From: Tom Errico <thomas.errico@tylin.com>
To: Jean Fraser <JF@portlandmaine.gov>
CC: David Margolis-Pineo <DMP@portlandmaine.gov>, Katherine Earley <KAS@port...>
Date: 9/17/2014 7:37 PM
Subject: 2282 Congress Street

Jean - I have reviewed the revised site layout, construction plan, and the off-site improvement plan and offer the following comments;

(B) BITUMINOUS SIDEWALK WITH GRANITE CURB DETAIL
 N.T.S.

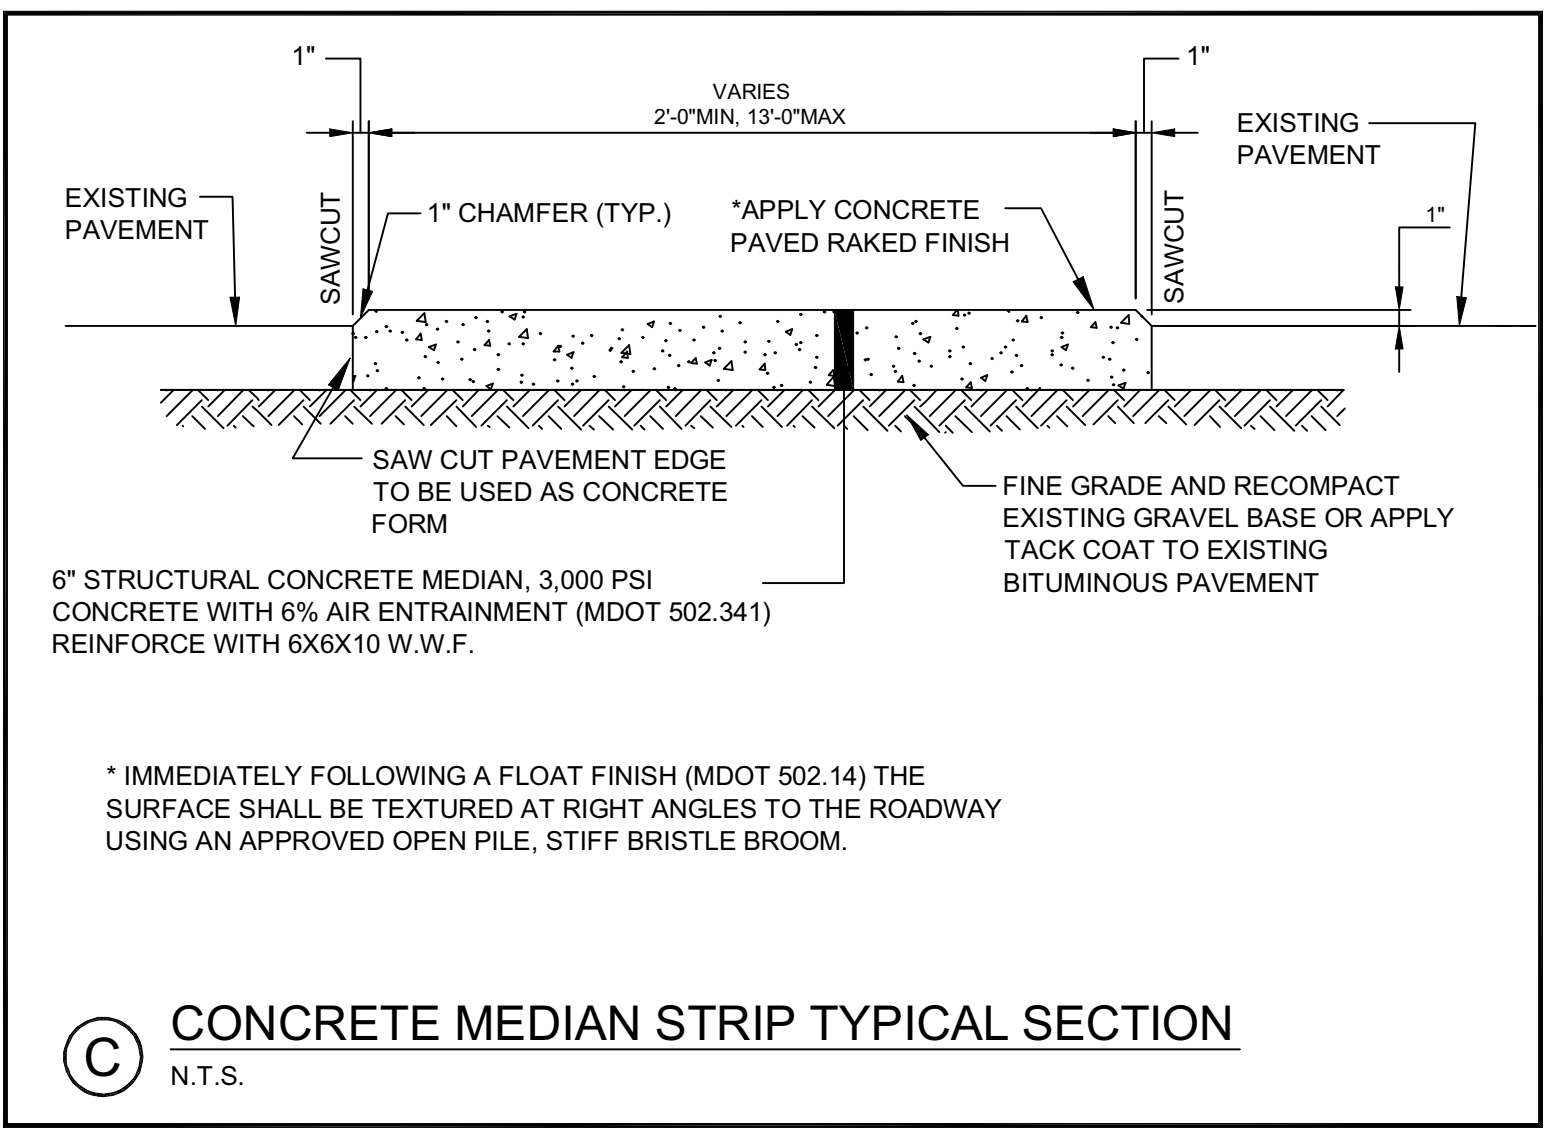
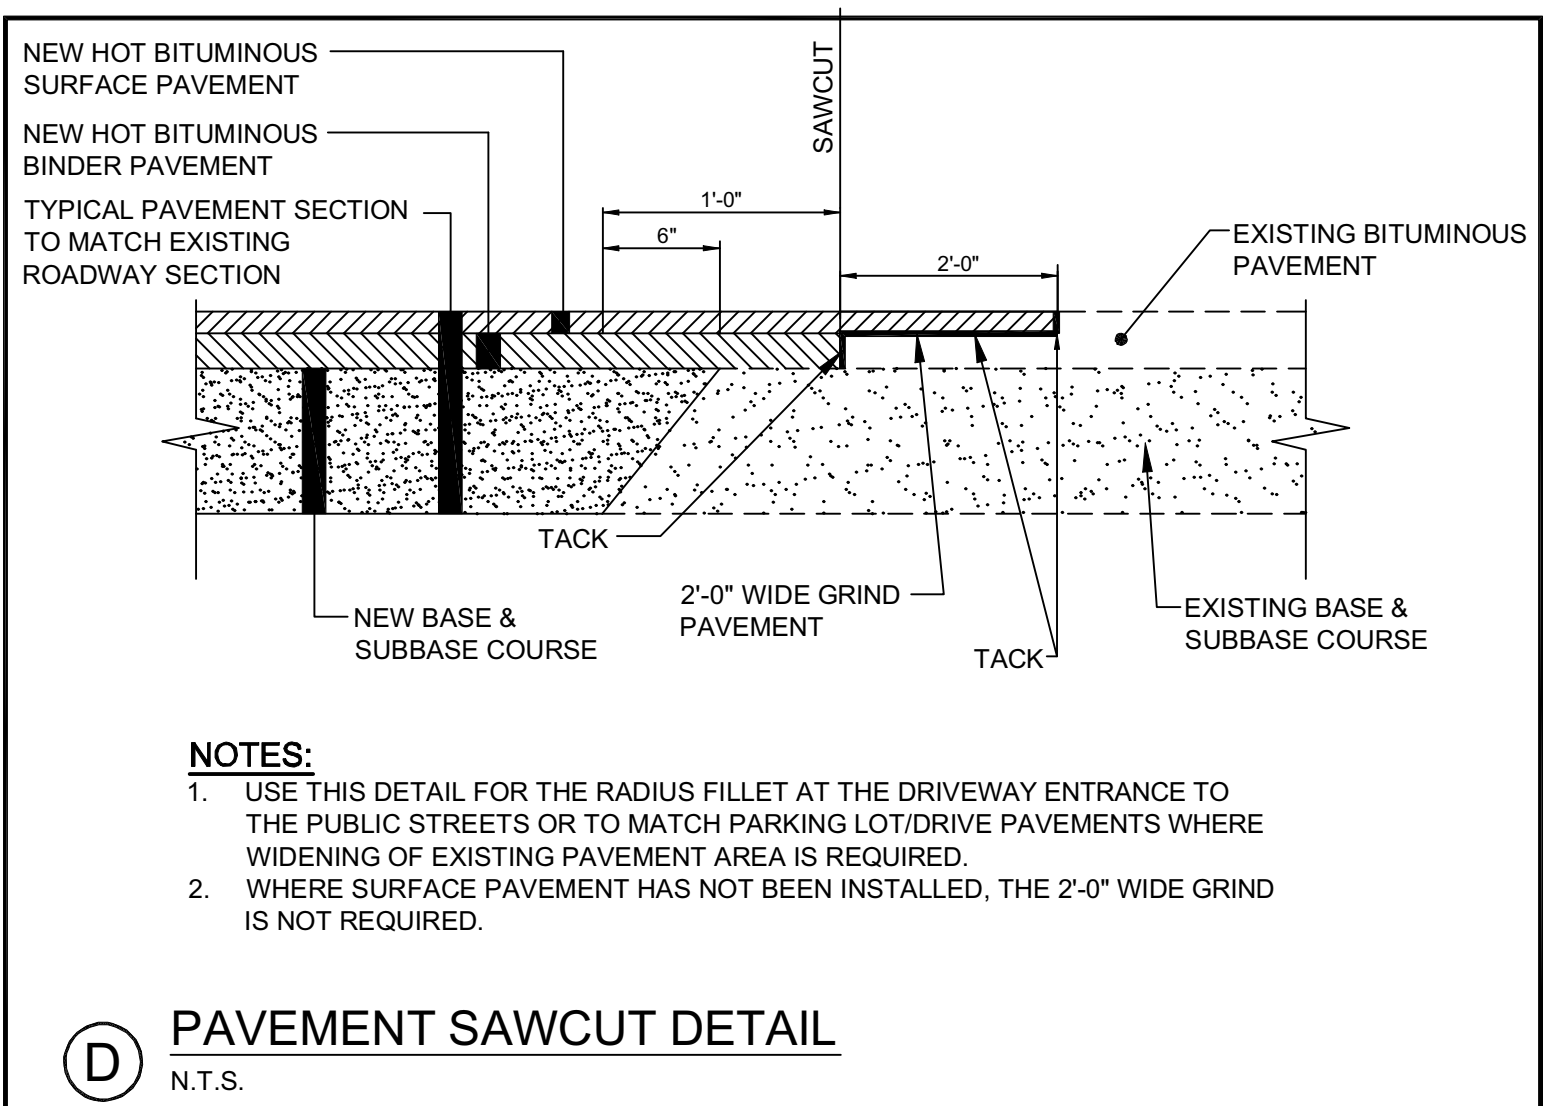
- * I find the site plan layout to be acceptable and I have no comment.
- * I find the construction plan to be acceptable with the requirement that a variable message board (s) be provided that notes use of Skyway Drive as an alternative route during construction.
- * The following are my comments regarding the improvement plan:
 - o The applicant should note why a minimum 5-foot shoulder is not provided (Please confirm that 4-feet is the existing width that the project is matching into)
 - o A detectible warning panel shall be installed on the easterly corner of Blueberry Road.
 - o Right-of-way boundaries on the north side of Congress Street should be provided and it should be confirmed that all activity will occur in the public right-of-way.
 - o A method for removal of existing conflicting pavement markings shall be provided for review and approval.
